## Fire Marshal Division

**Re: Meredith Square Apartments  
603 Main St.  
Lillington, NC 27546**

**Application Number CFFB18-50044464**

Thank you for submitting the fire alarm plans for the apartments. The plans have been carefully reviewed by a qualified code enforcement official to examine for compliance with the North Carolina Fire Prevention Code and all other fire protection regulatory documents. There are some items that were found during the plan review process that need to be addressed before a final inspection of the new facility can be given. These items are outlined and described below.

H14 Building Type 1 Life Safety Floor Plan SCALE: 1/8" = 1'-0"

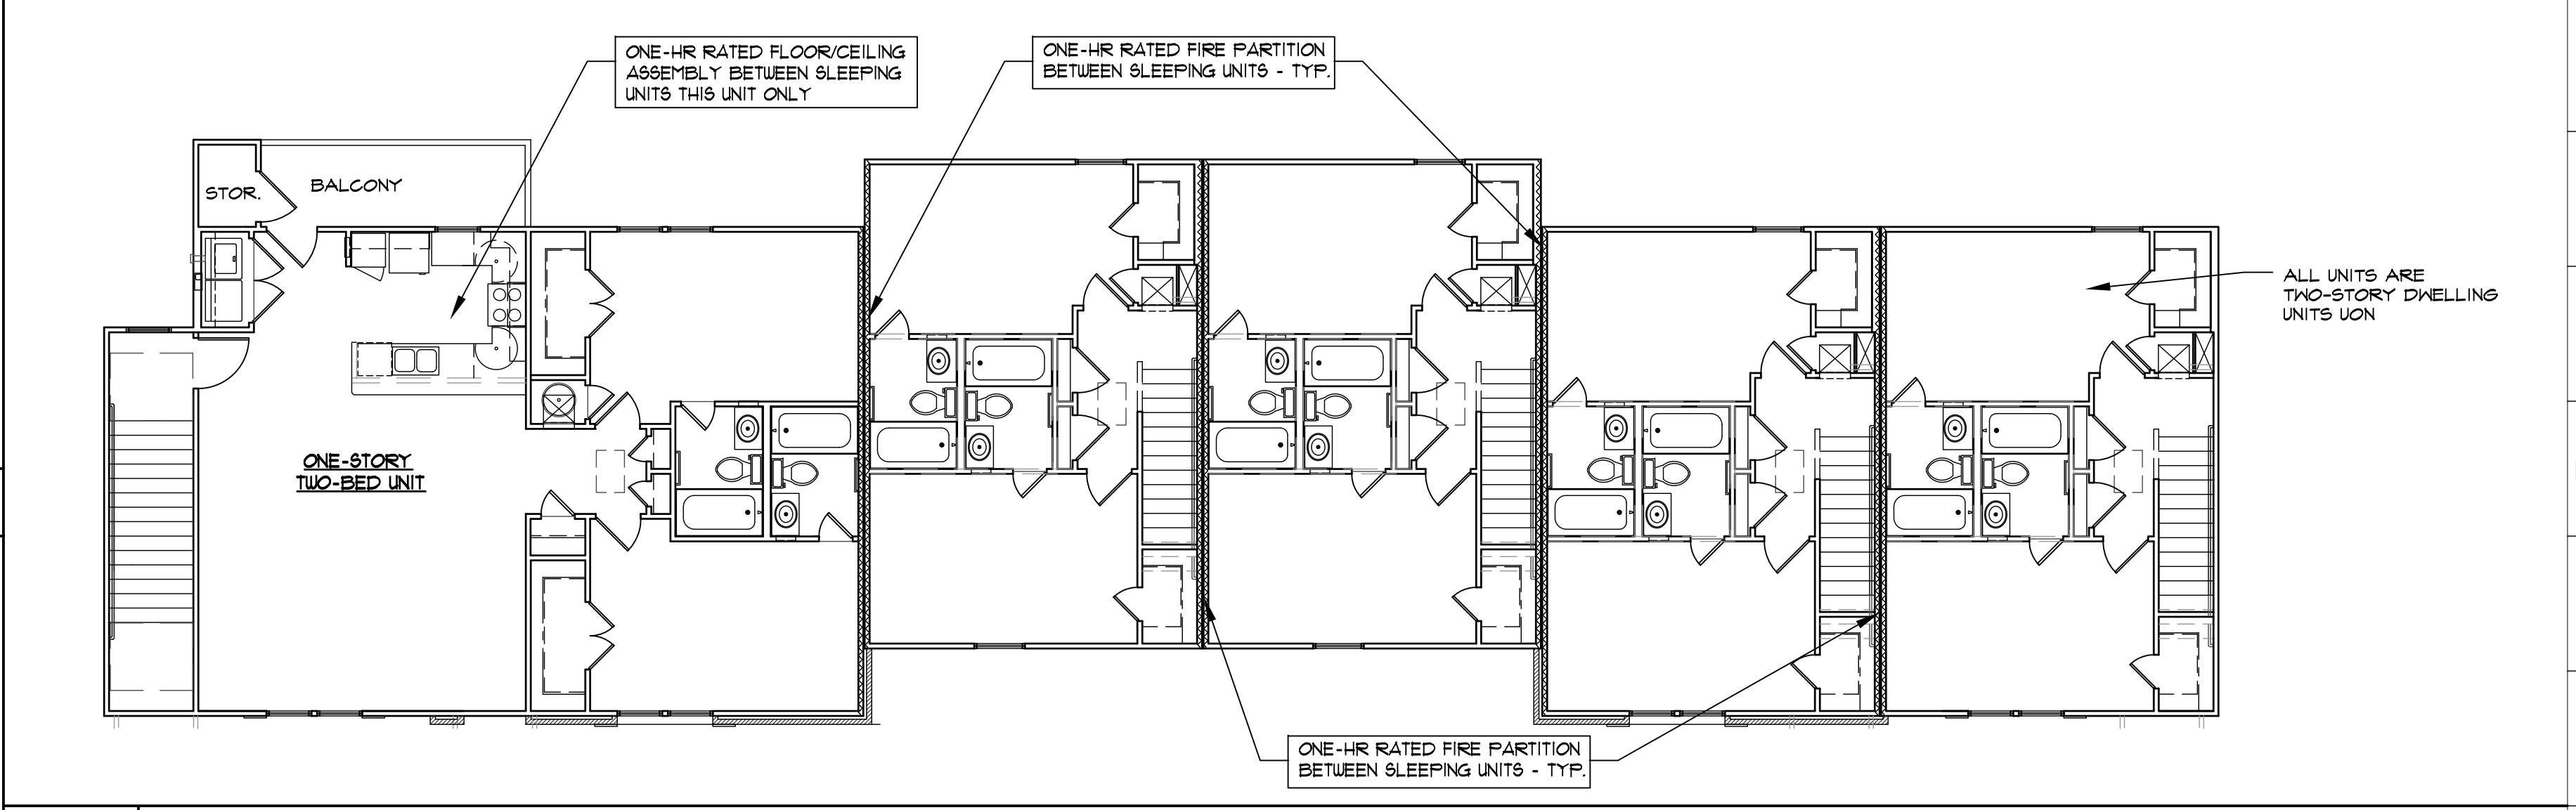
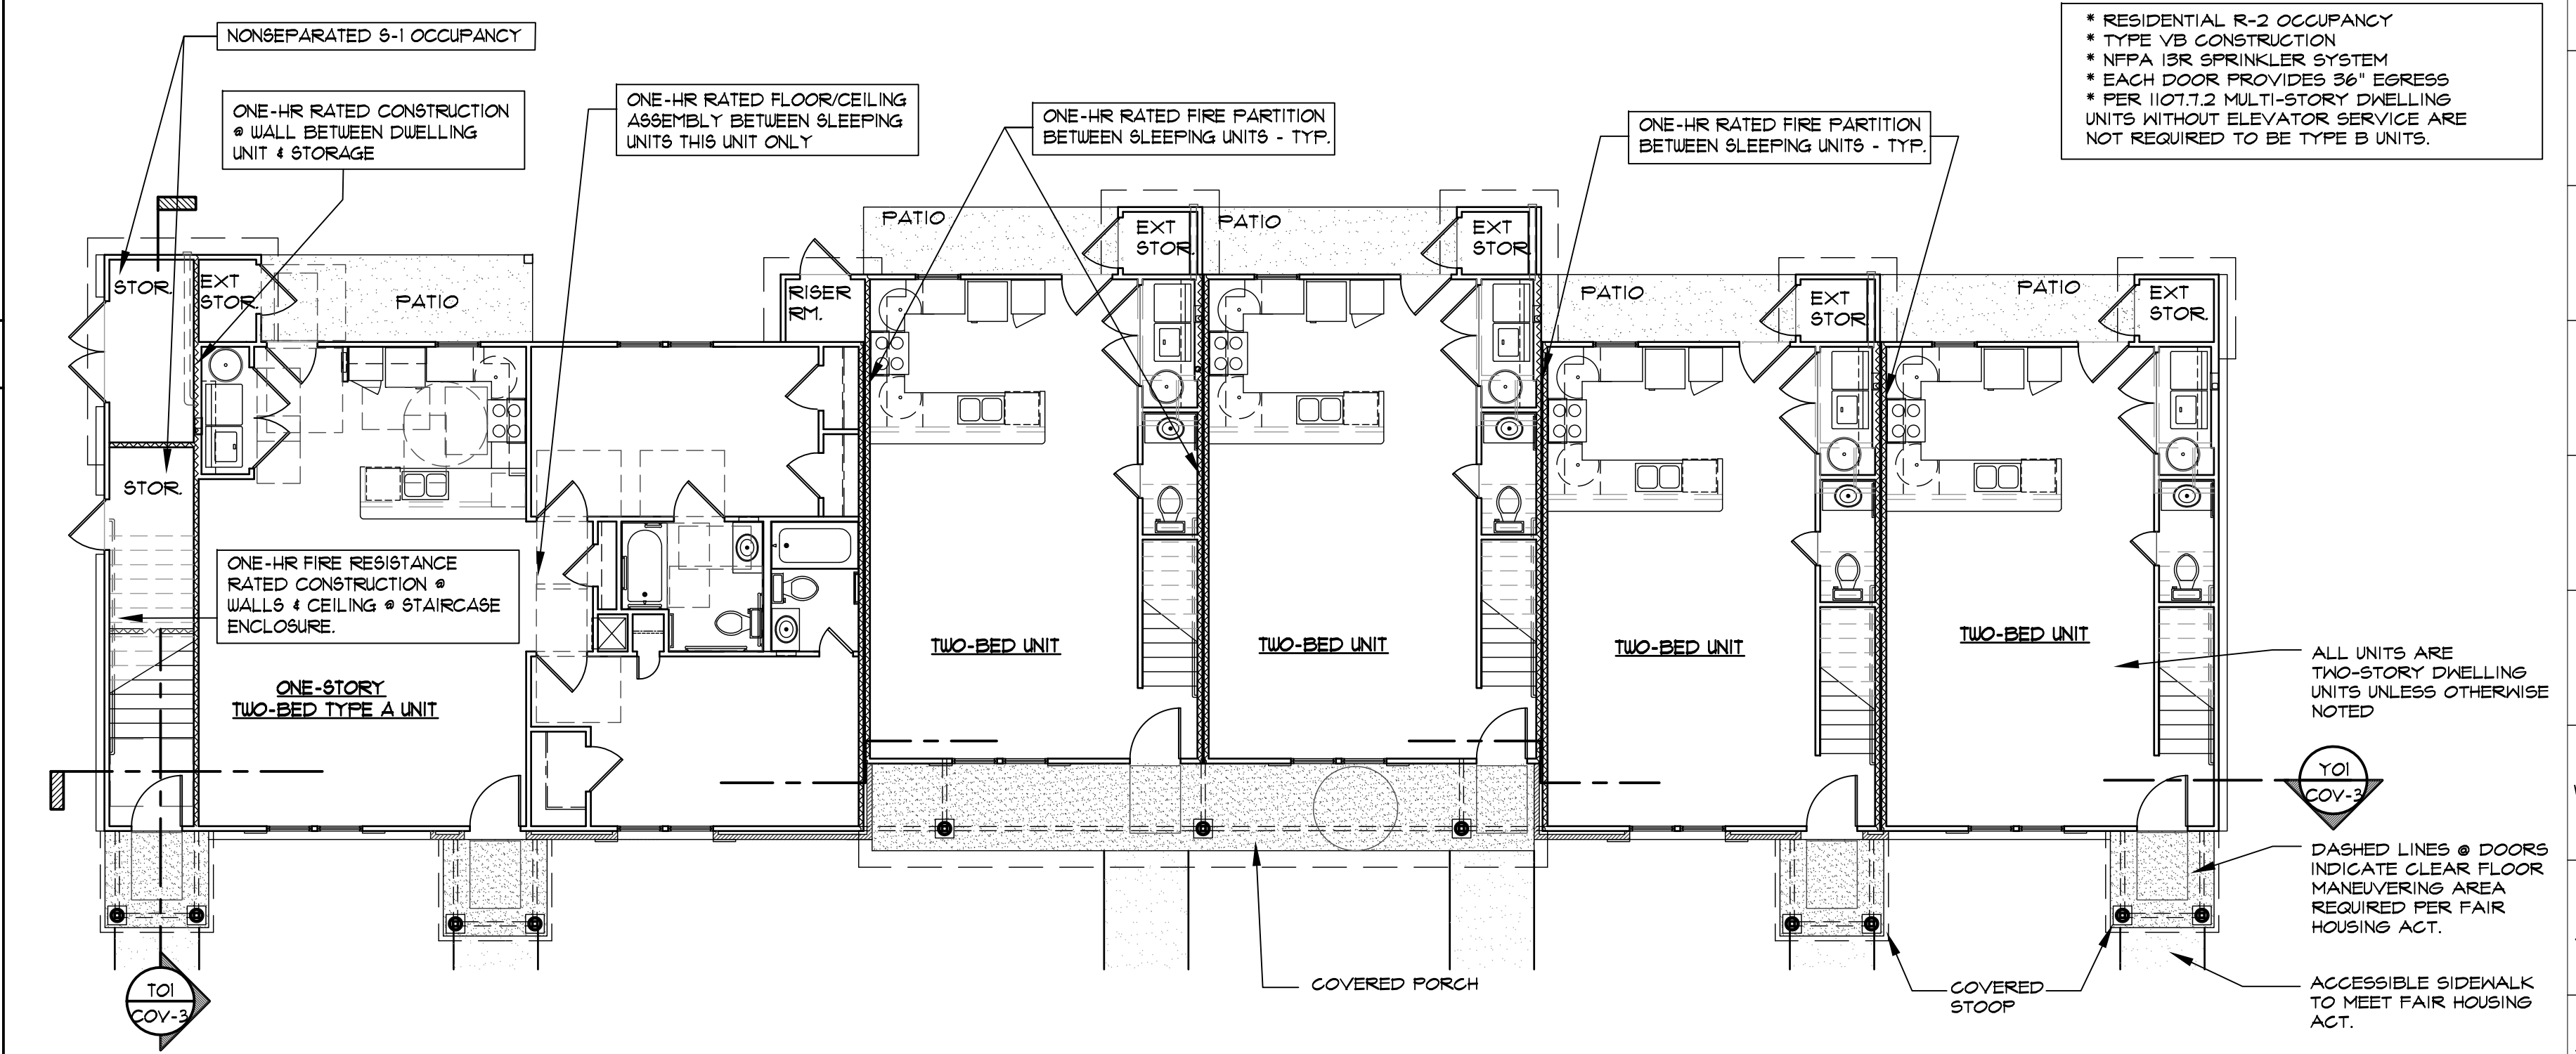
- Details of ceiling height and construction.
  - The interface of fire safety control functions.
  - The current plans include the basic device layout, but does not include the other required information.

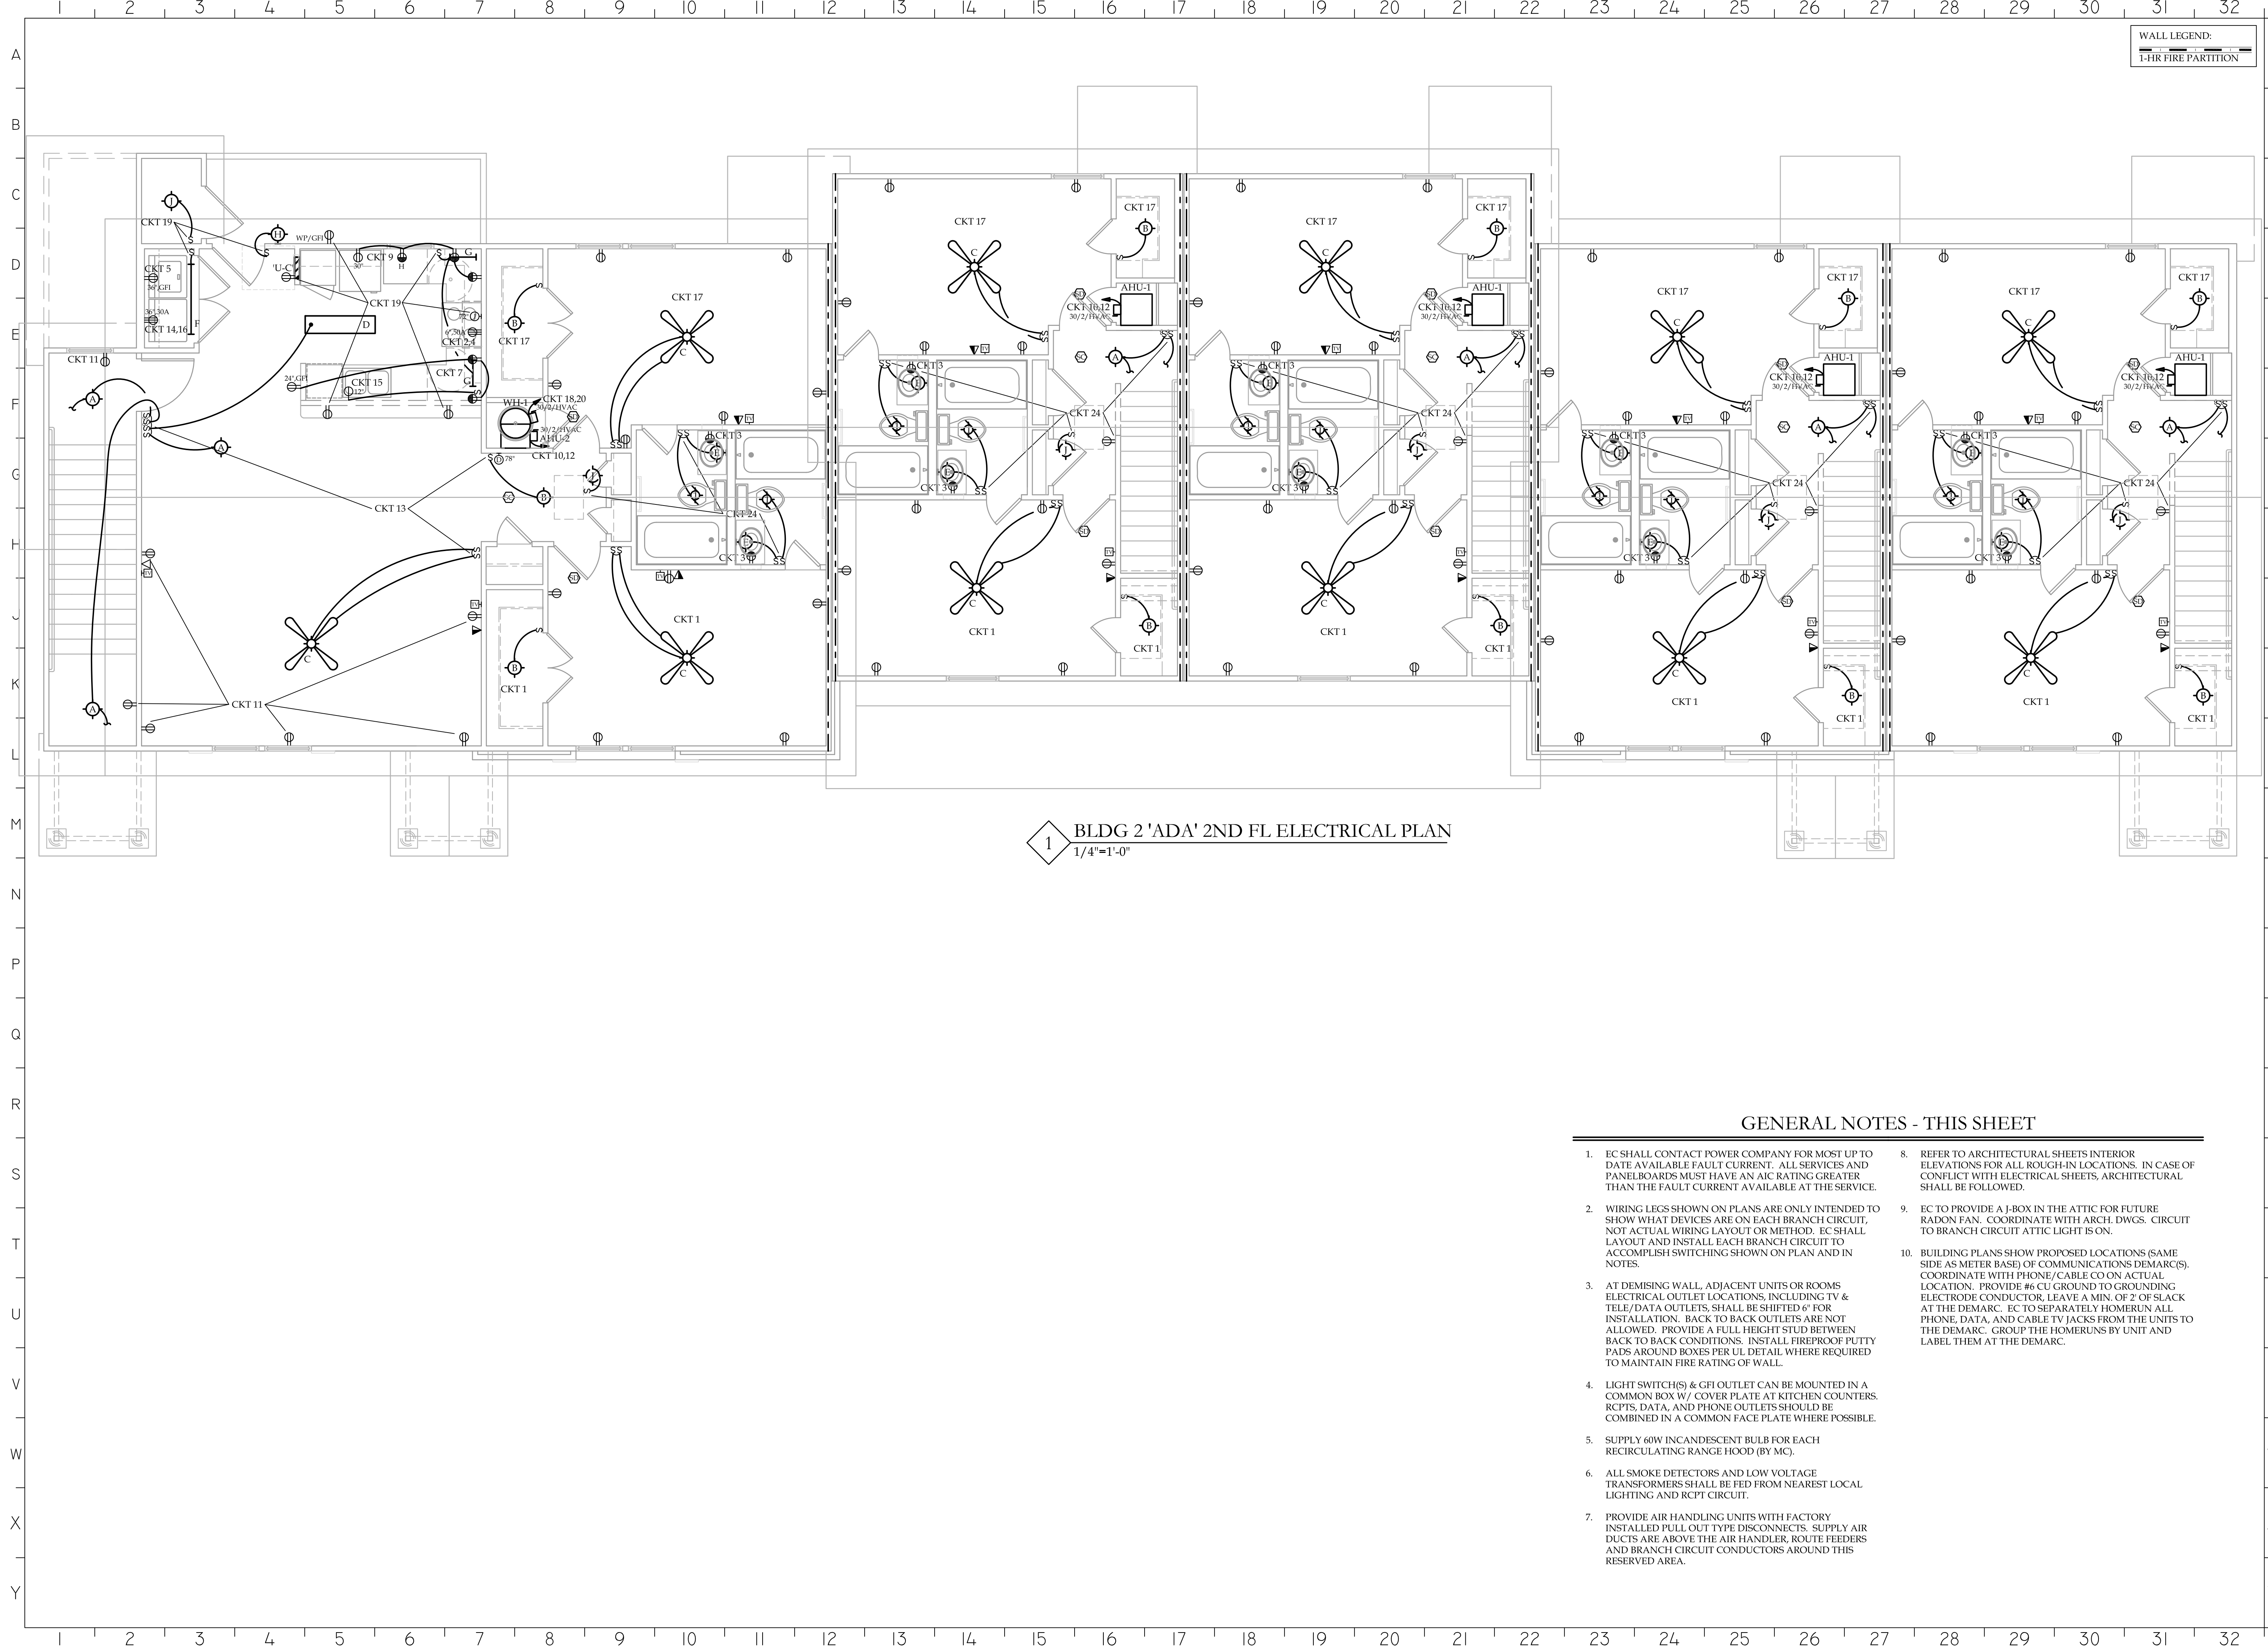
- **Notes**
  - Please specify the in-consistency in the placement of horns/strobes/horn-strobes on the second and third levels; and the lack of audio/visual devices in some bathrooms/sleeping areas.
  - Please call (910) 893-0742 to schedule all inspections.
